CITY OF ALBUQUERQUE

October 23, 2014

**RE: A Class Mega Storage
Grading and Drainage Plan
Engineers Stamp Date 10/6/14 (F15D52B)**

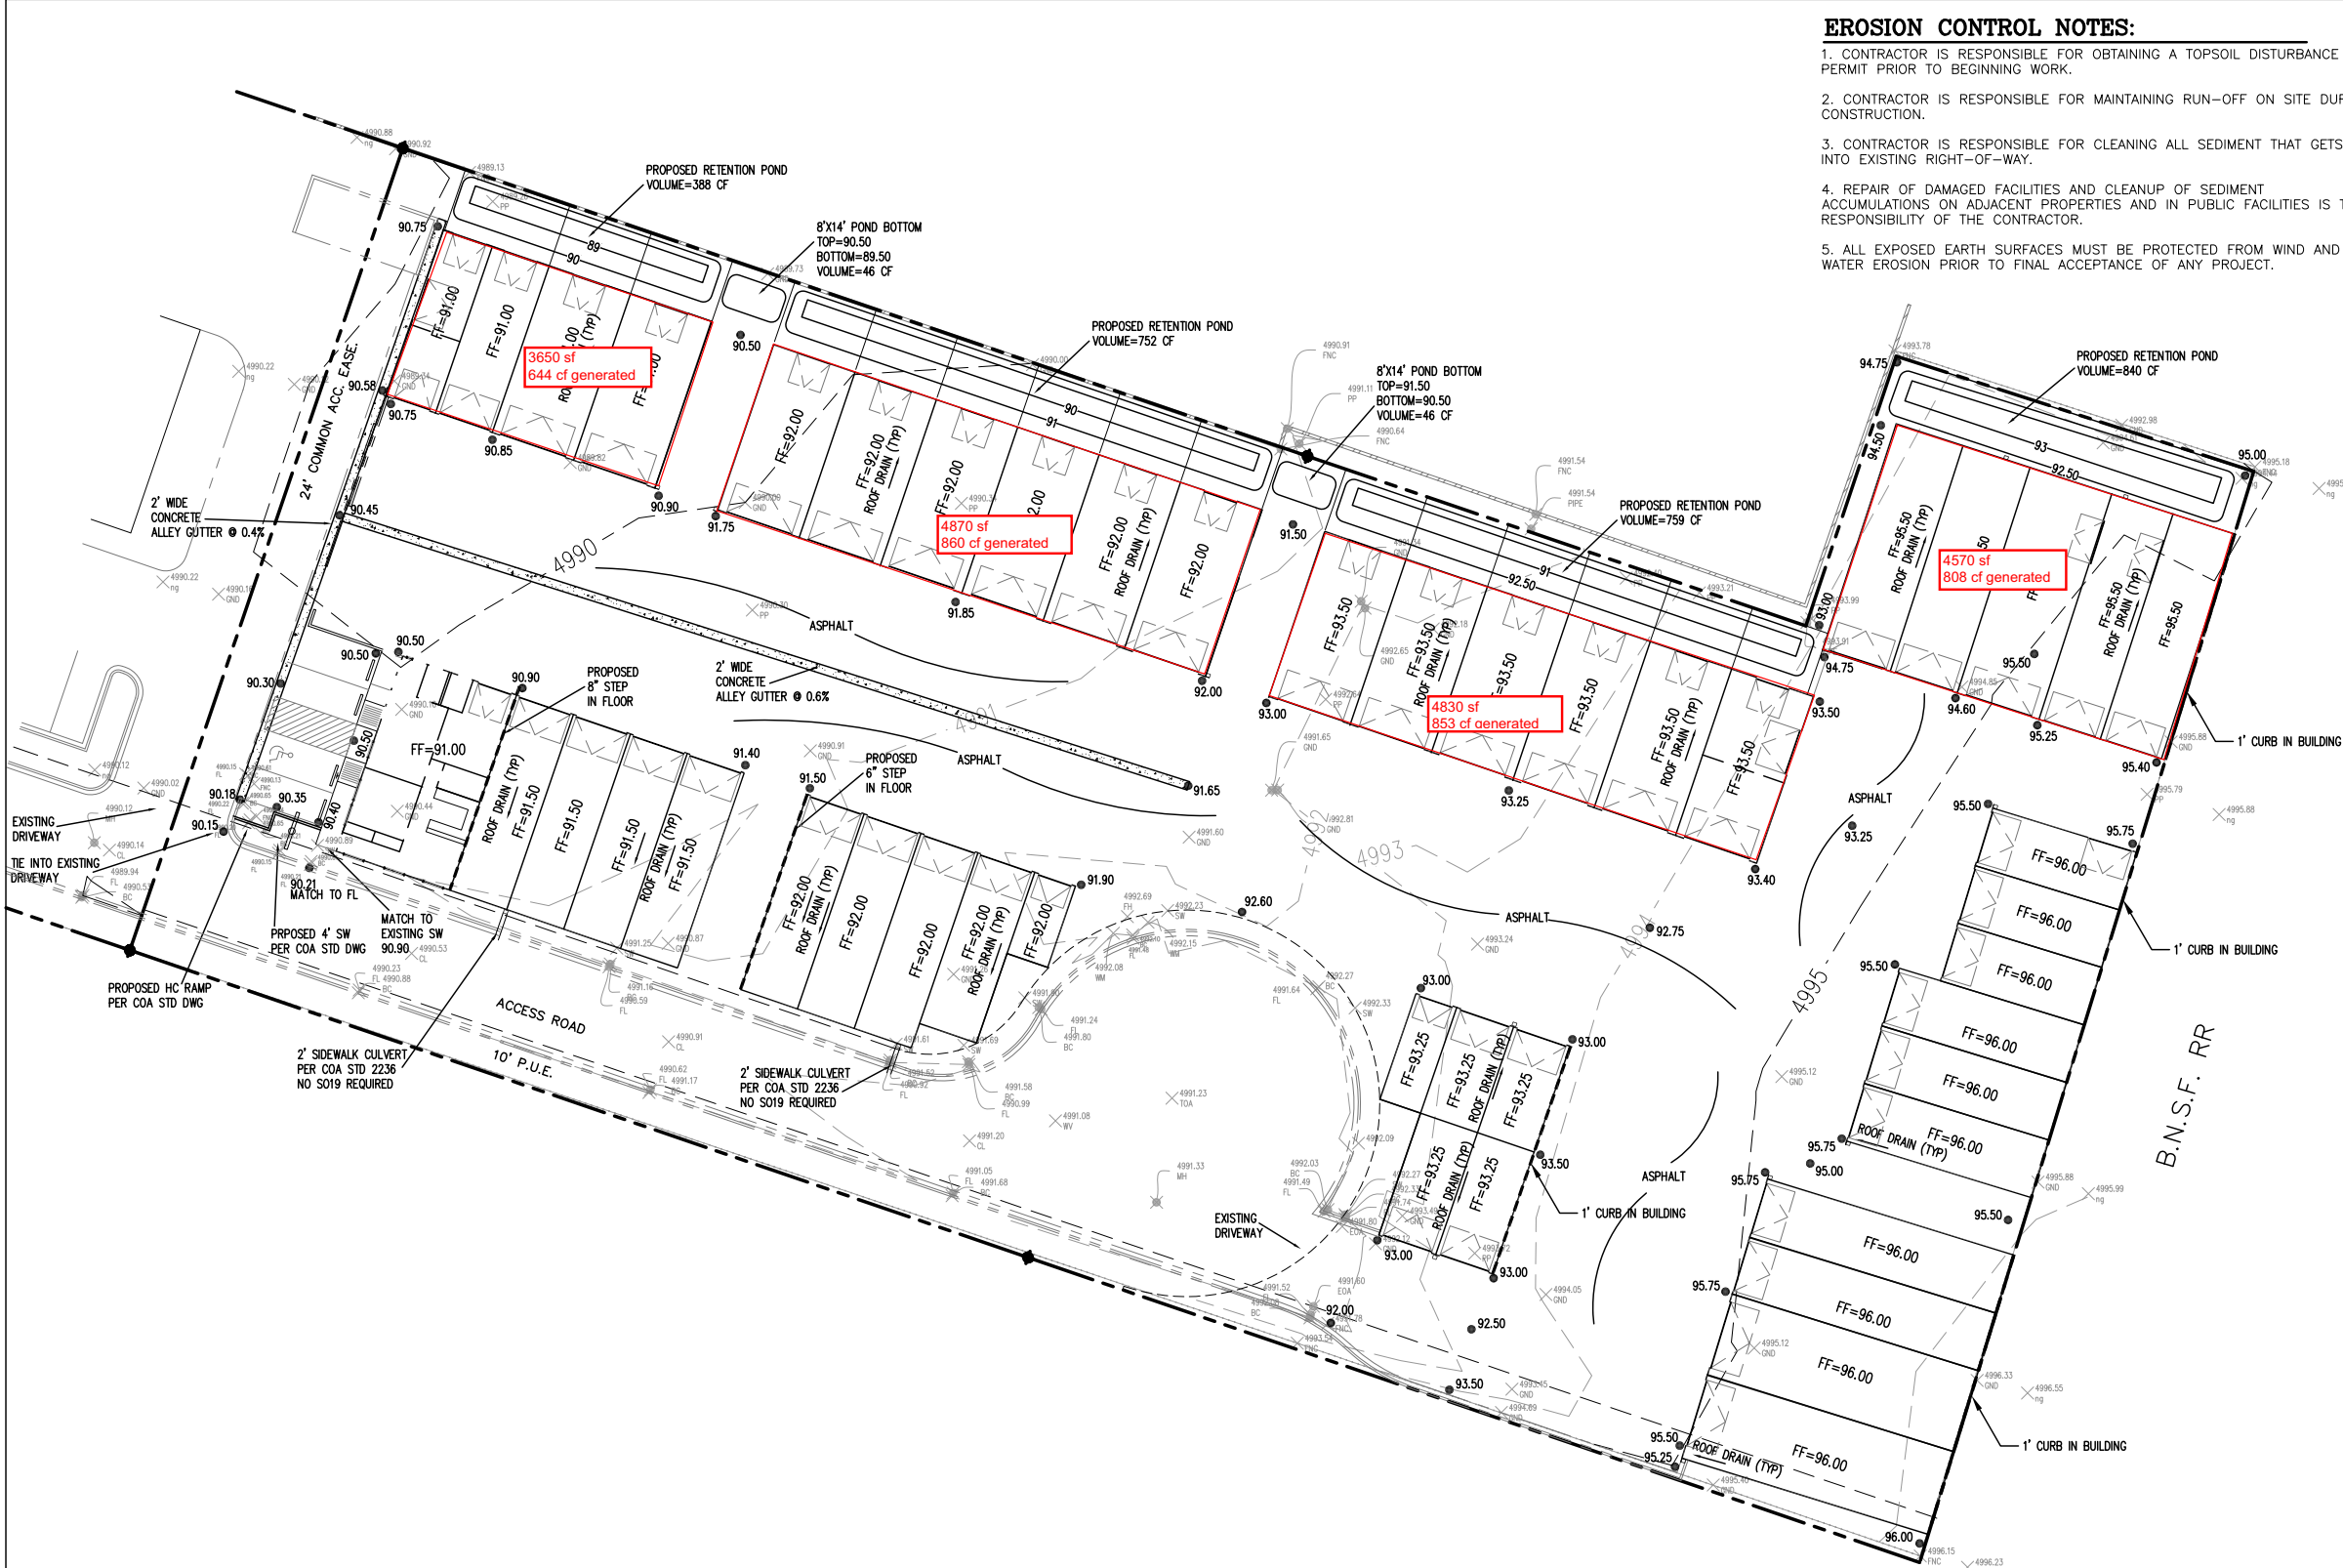
1. On the calculations, show the runoff volume of each individual building segment along the north property boundary in order to compare runoff to the pond volumes directly behind it.
2. Show that the cascading ponds are interconnected, and that the overflow discharges to the next pond until it outfalls to the alley gutter. Is there a wall along the North property boundary that would prevent overflow from discharging to the north? If so, indicate on the plans.
3. The last pond in the series discharges to an alley gutter, but the alley gutter is higher than the access. Can the alley gutter be moved to the lower side of the access? How does overflow from the lowest pond get to the alley gutter without overflowing to property to the North?
4. Show Benchmark.
